# CITY OF ALBUQUERQUE

**Re: Tract A of El Cambino Plaza Addition, 511 Bridge Blvd., Traffic Circulation Layout, Architect's Stamp dated XX-XX-XX (L14-D55)**

Based upon the information provided in your submittal received 02-27-06, the above referenced plan cannot be approved for Building Permit until the following comments are addressed:

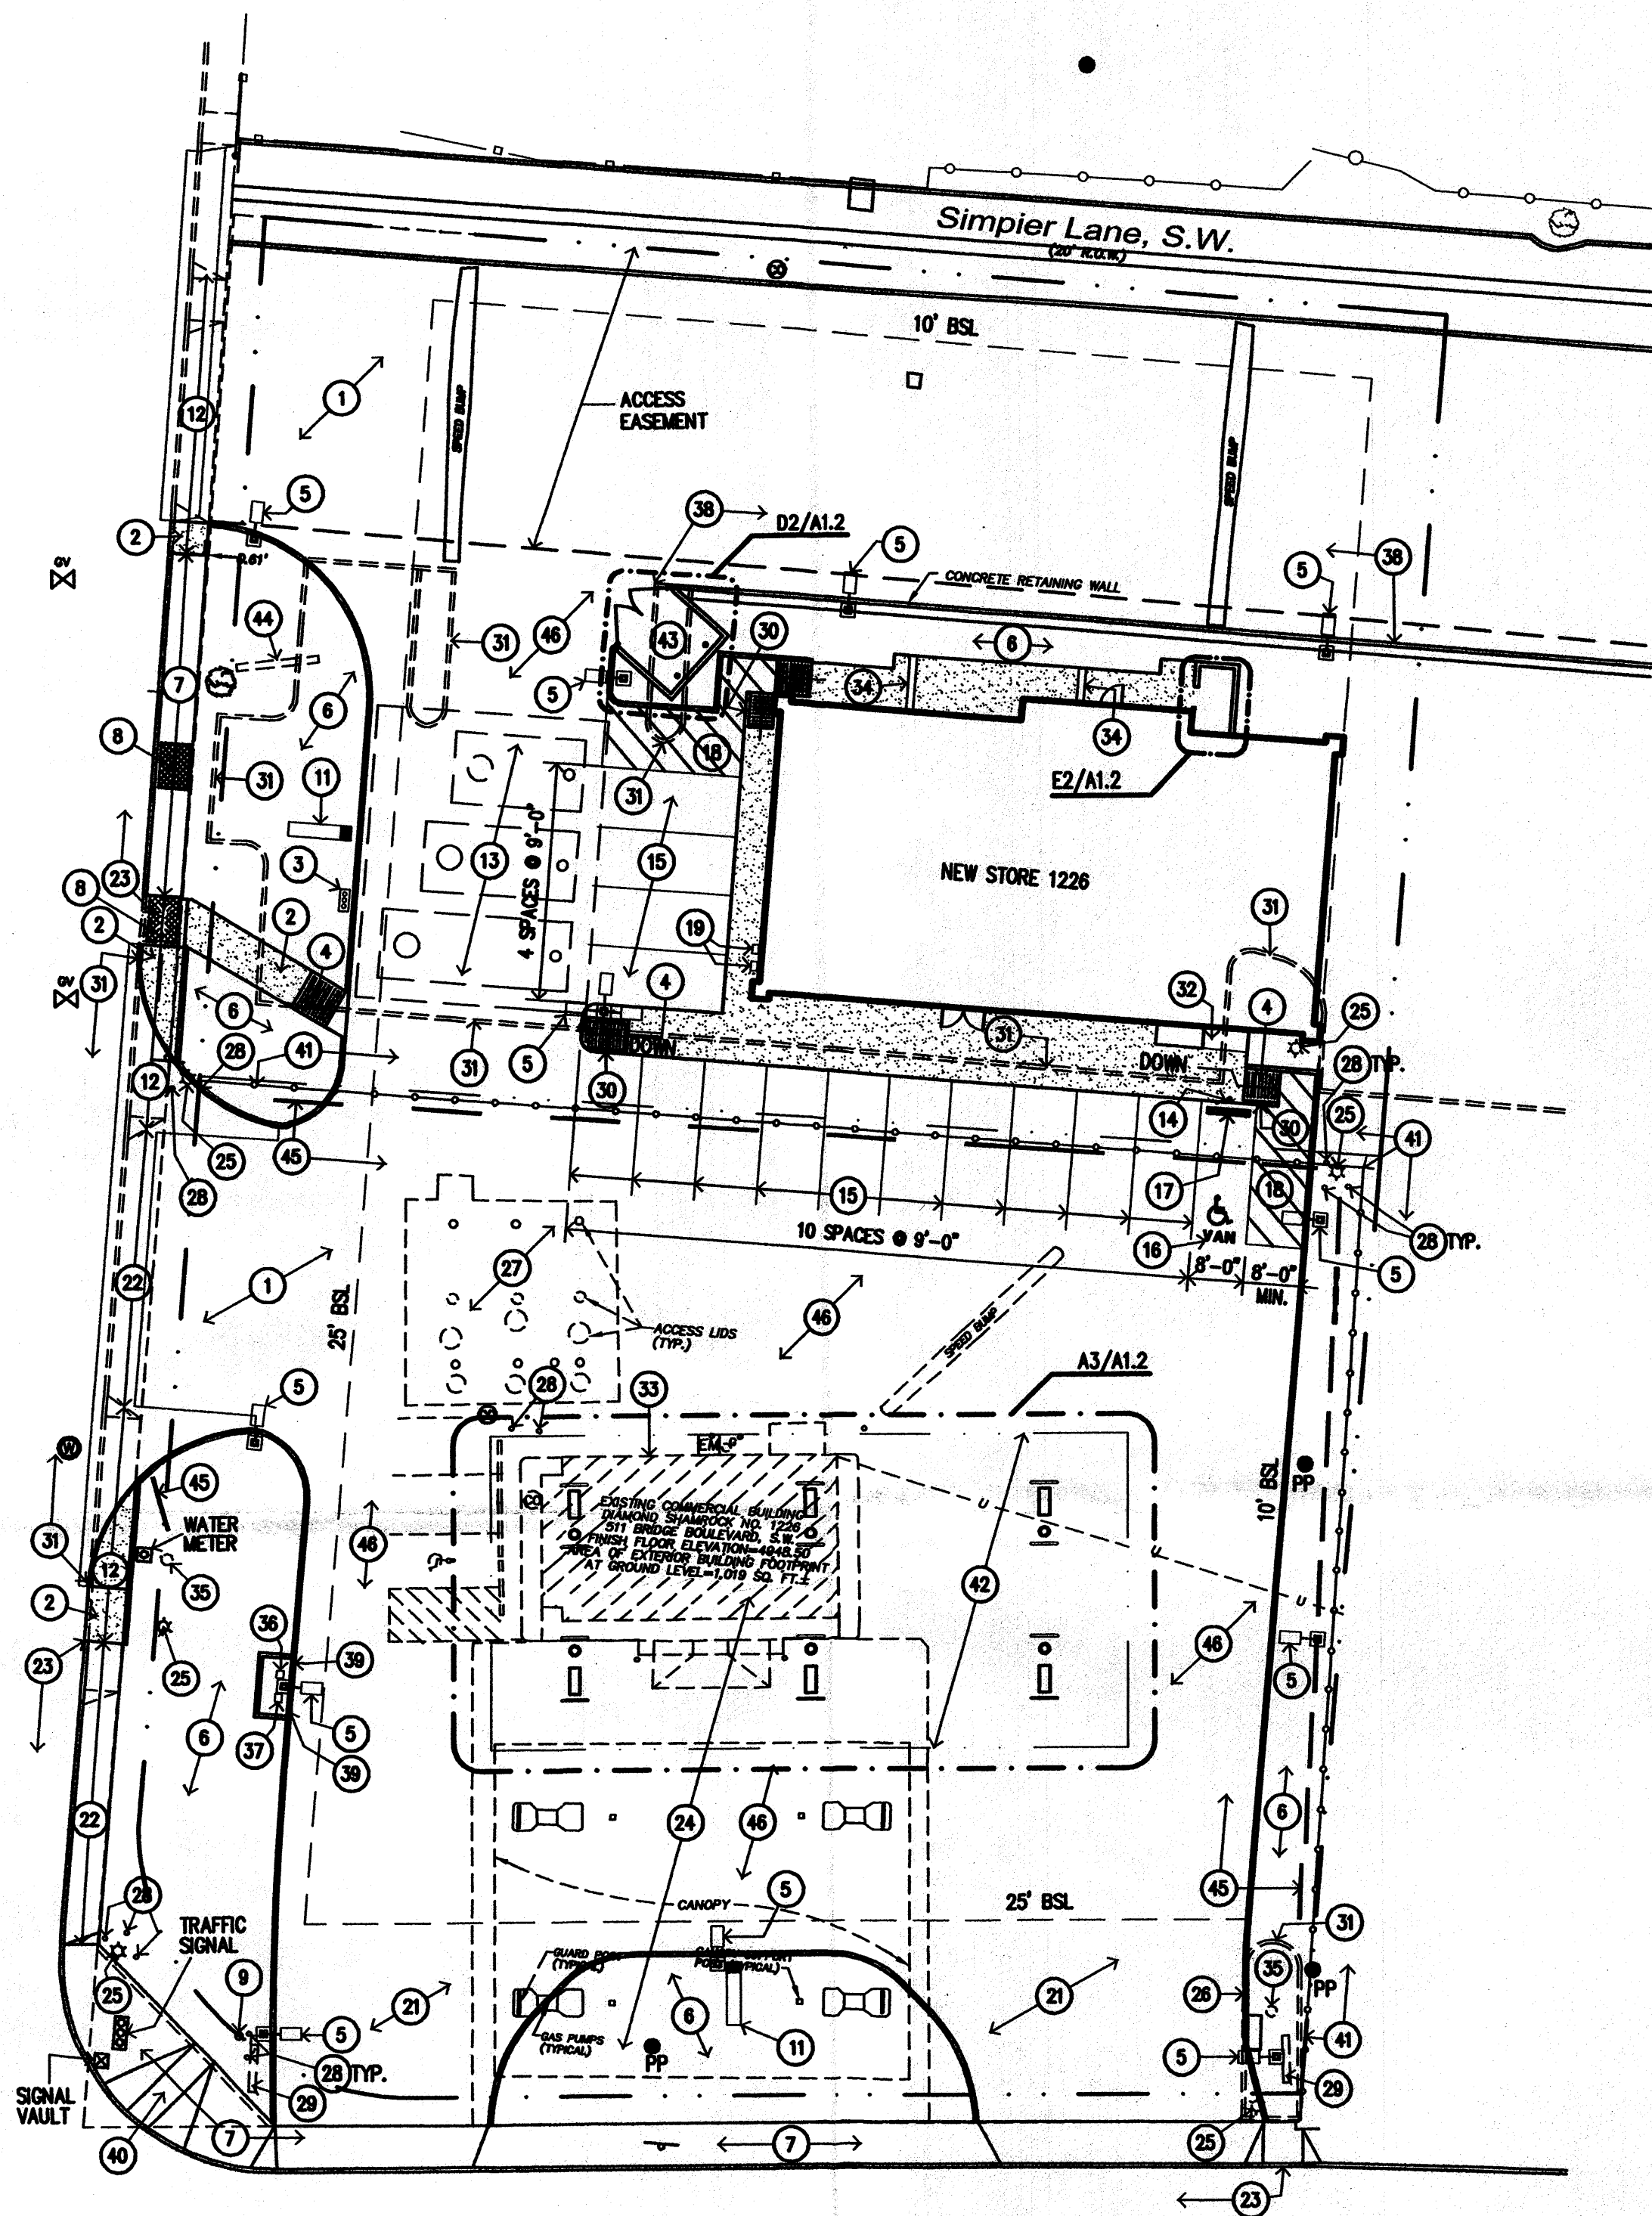
1. Please, refer to all appropriate City Standards; the drawing number should be included in this reference; these numbers refer to the curb & gutters, drive-pads, and sidewalks.
2. Provide the width for all sidewalks. (proposed and existing)
3. Include the dimensions, (lengths and widths), of the parking stalls.
4. Provide parking calculations.
5. Provide a vicinity map of the project.
6. Include the widths of entrances. (proposed and existing)
7. Will a cross lot access easement be required?
8. Parking will need to be contained on-site; if this not possible the site will need to be re-plated.
9. A stamped, dated, and signed plan will need to be submitted for next review.
